Application No: BR/213/21/HH
Site Address: 12-14 The Steyne Bognor Regis PO21 1TP
Description of works: Erection of front porch extension, installation of first floor double balcony and external facade alterations (This application may affect the character and appearance of The Steyne, Bognor Conservation Area)

Thank you for your internet representation made on 13th November 2021 which has been recorded as an objection with the comments as follows:

DRAWING: Front Facade Alterations			
TITLE: Proposed Plans and Elevations			
SCALE AT A1: 1 : 50	DATE: Issue Date	DRAWN: EL	CHECKED: AP
PROJECT NO: The Styn	DRAWING NO: WLD-010-21-05	REVISION:

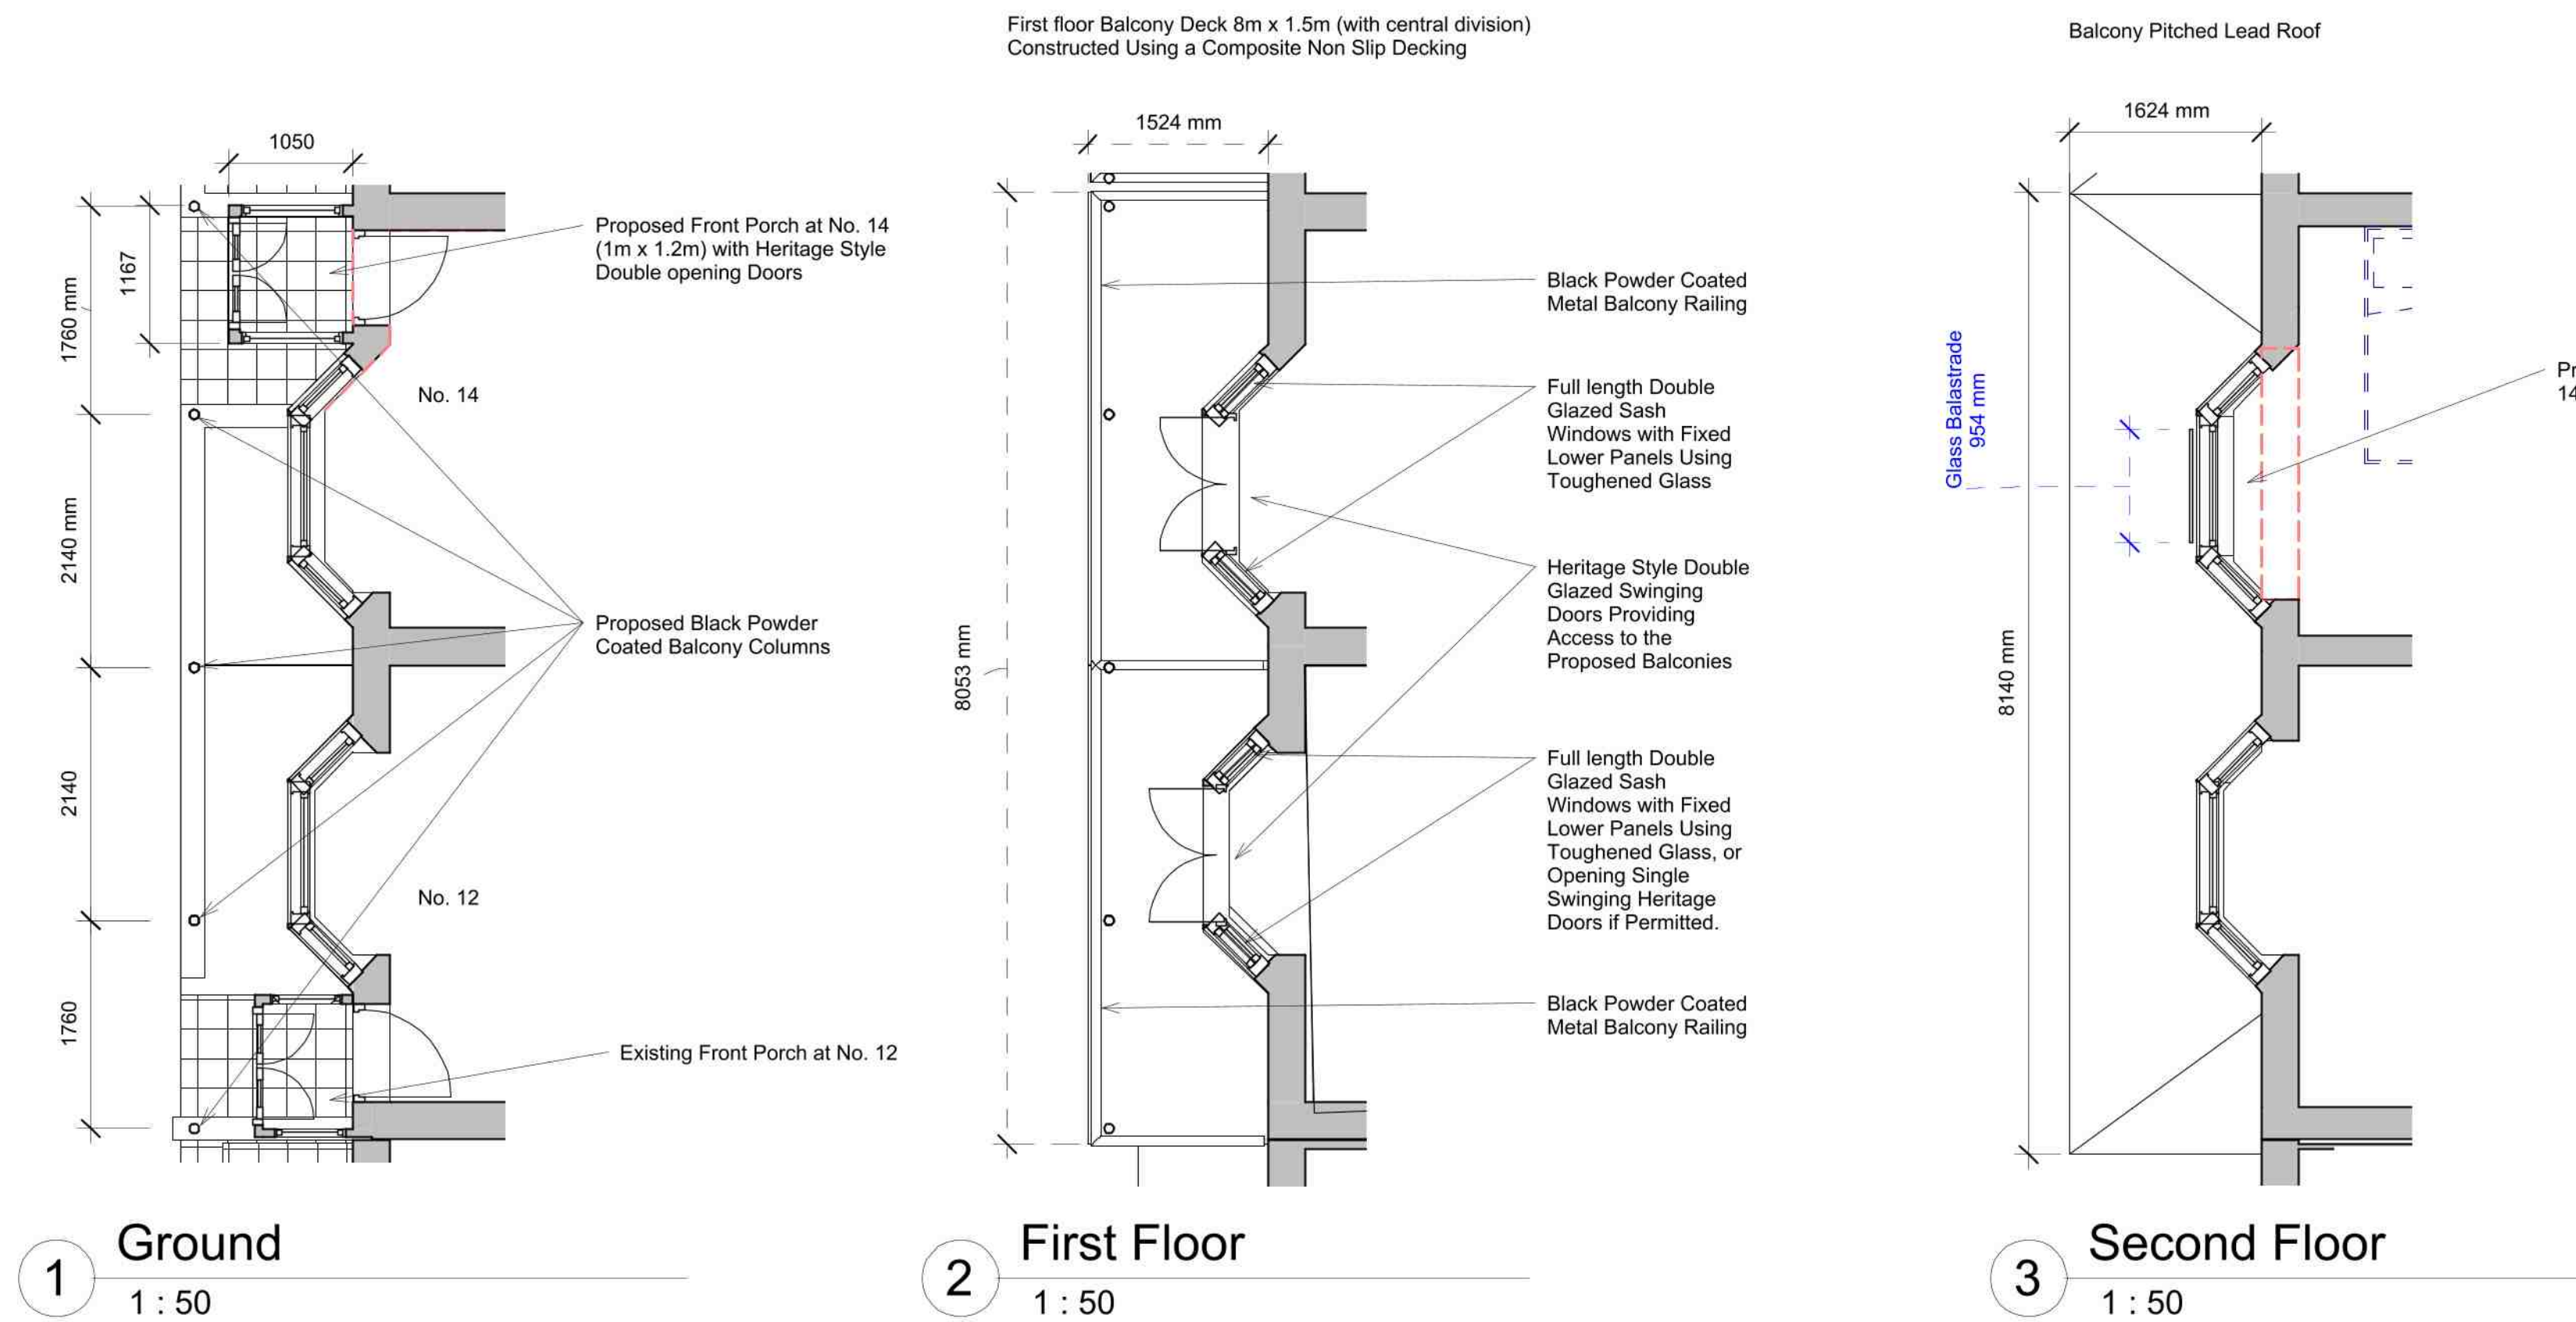
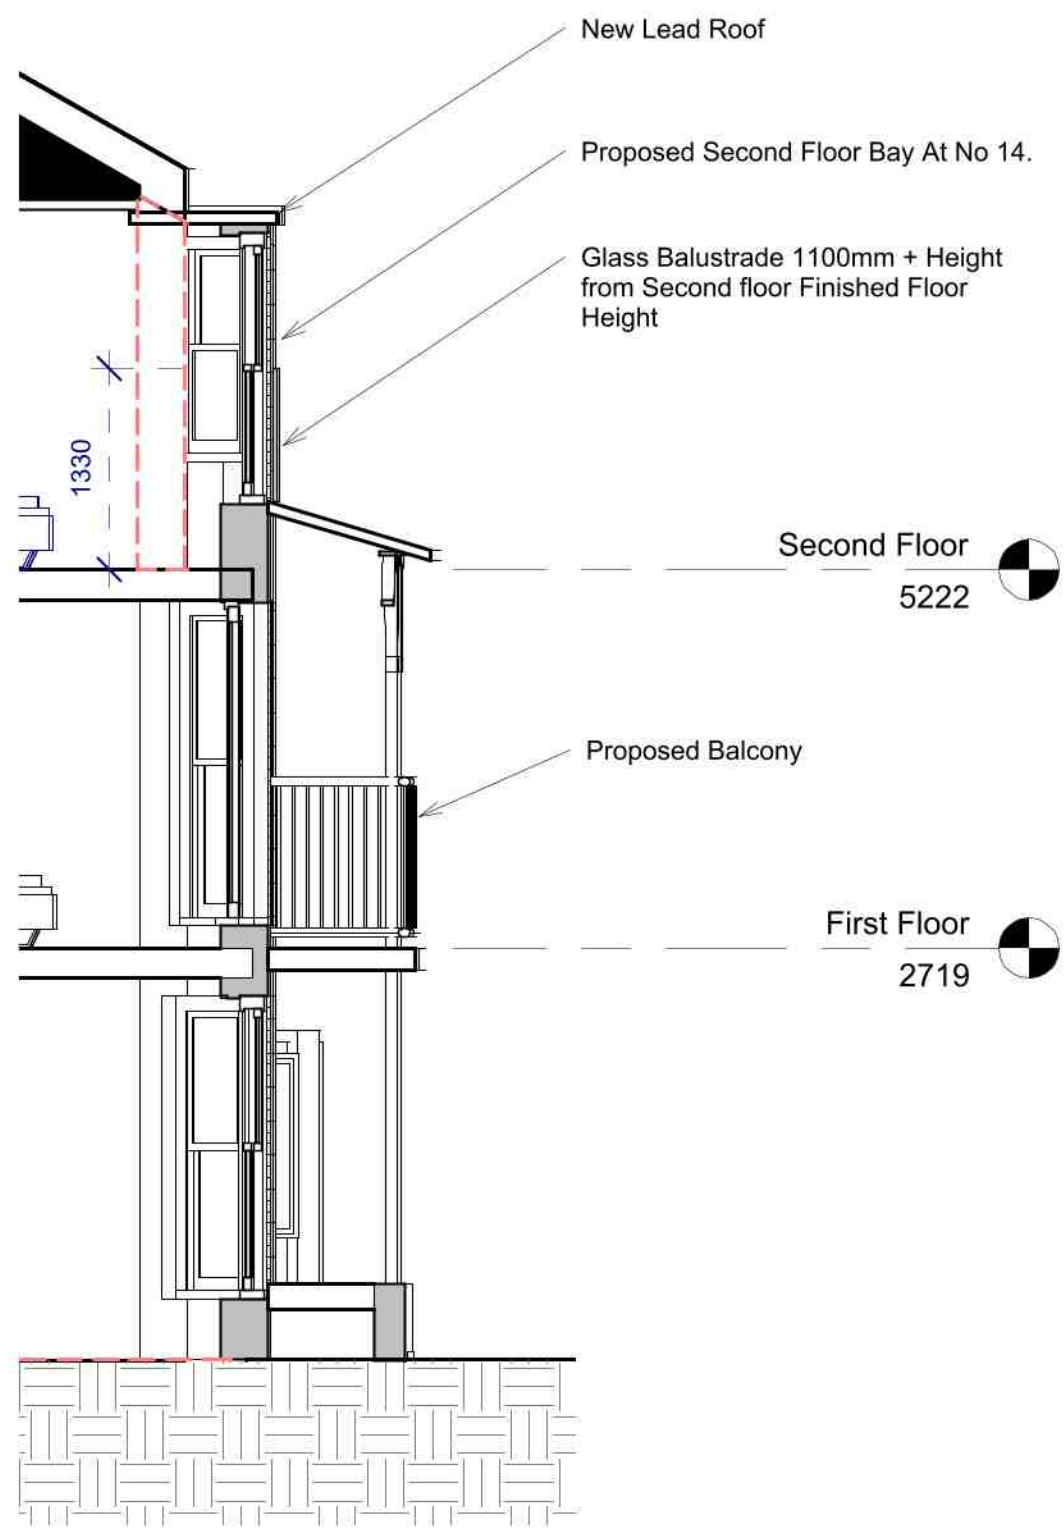
While I have no objection to the erection of balconies in principle, the proposed balconies are significantly deeper than the neighbouring balconies which are wider properties. As a result they will be noticeable in jutting out over the road and be out of proportion with the surrounding properties and The Steyne Conservation Area. I also have some concern that the proposed Juliet balcony on the top floor of #14 includes a glass front, which is not in keeping with the style of the house or neighbouring properties. If these details were revised to bring the proposed changes in line with the style of The Steyne Conservation Area, I would have no objection to the erection of the balconies.
